Recommendation Report for Planning Permission for Works or Extension to a Dwelling

REF NO: BN/150/21/HH

LOCATION: 1 Bateson Way
Barnham
PO22 0FL

PROPOSAL: Erection of single storey rear extension.

BH/BW/03

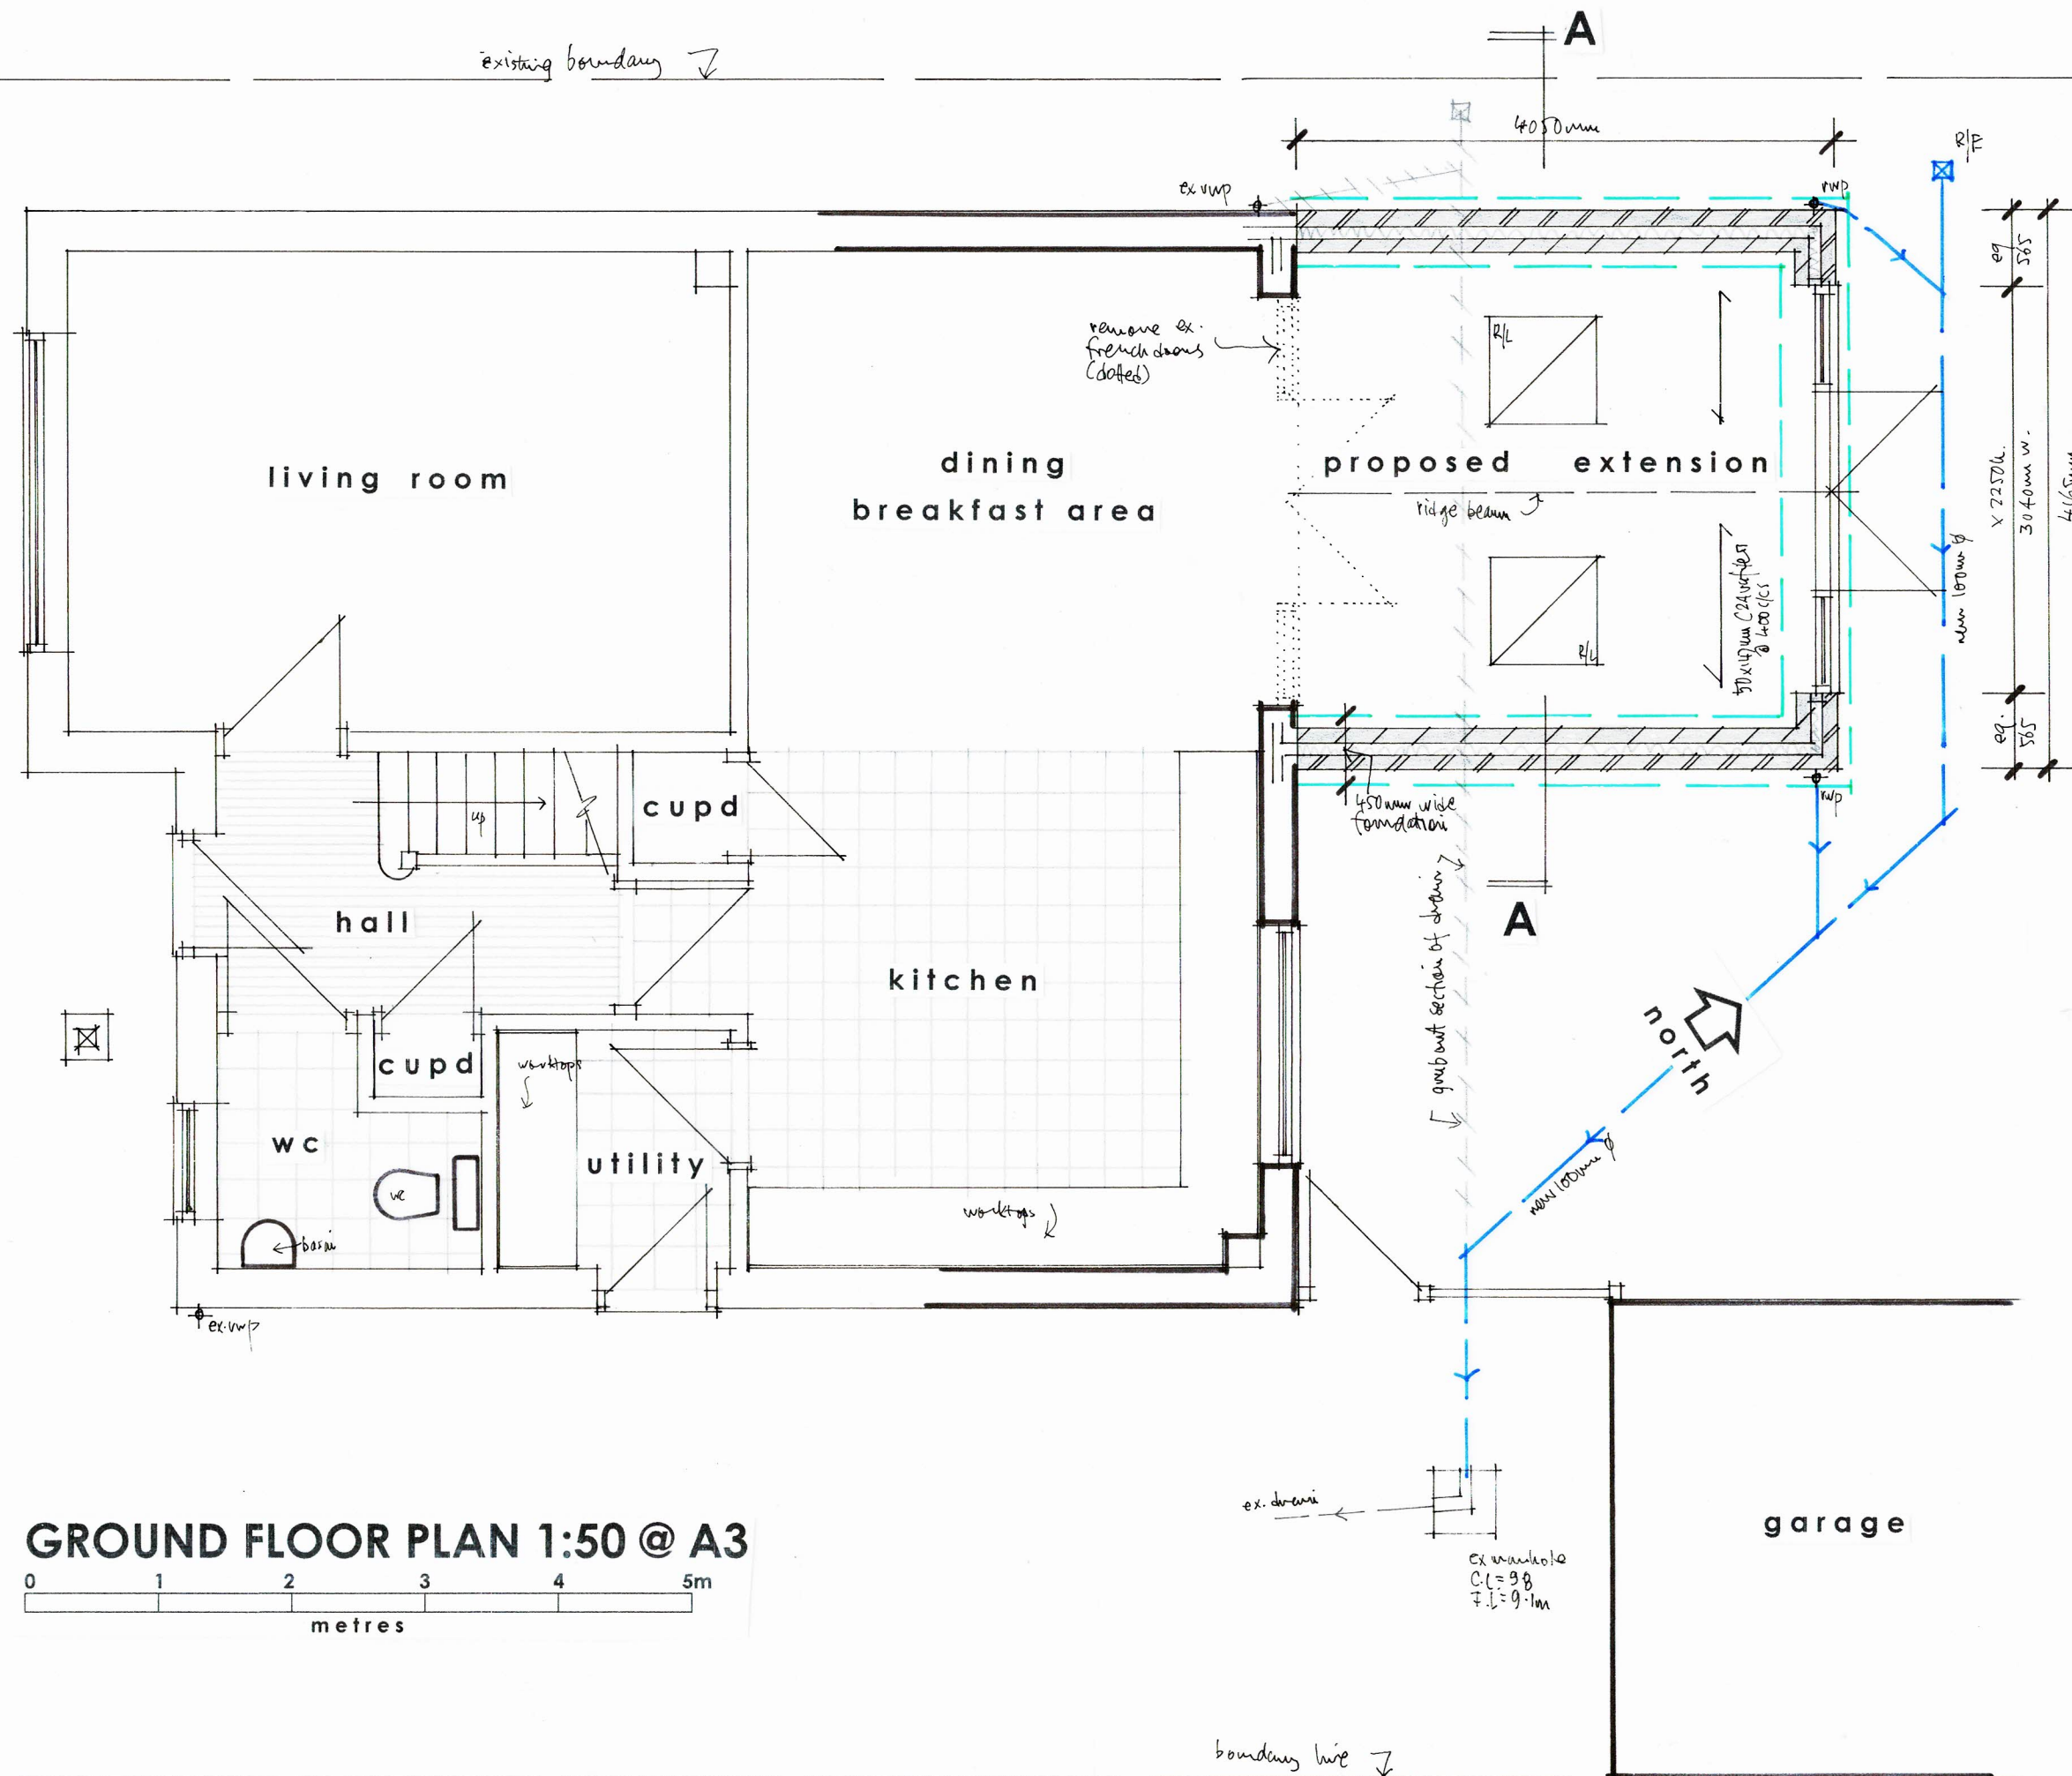
Drainage - Apply condition relating to surface water drainage.

updated 13/1/21/ - On the basis of Drawing BH BW 03A. I ask that my request for the application to be conditioned is disregarded. Surface water drainage must be constructed in accordance with said drawing.
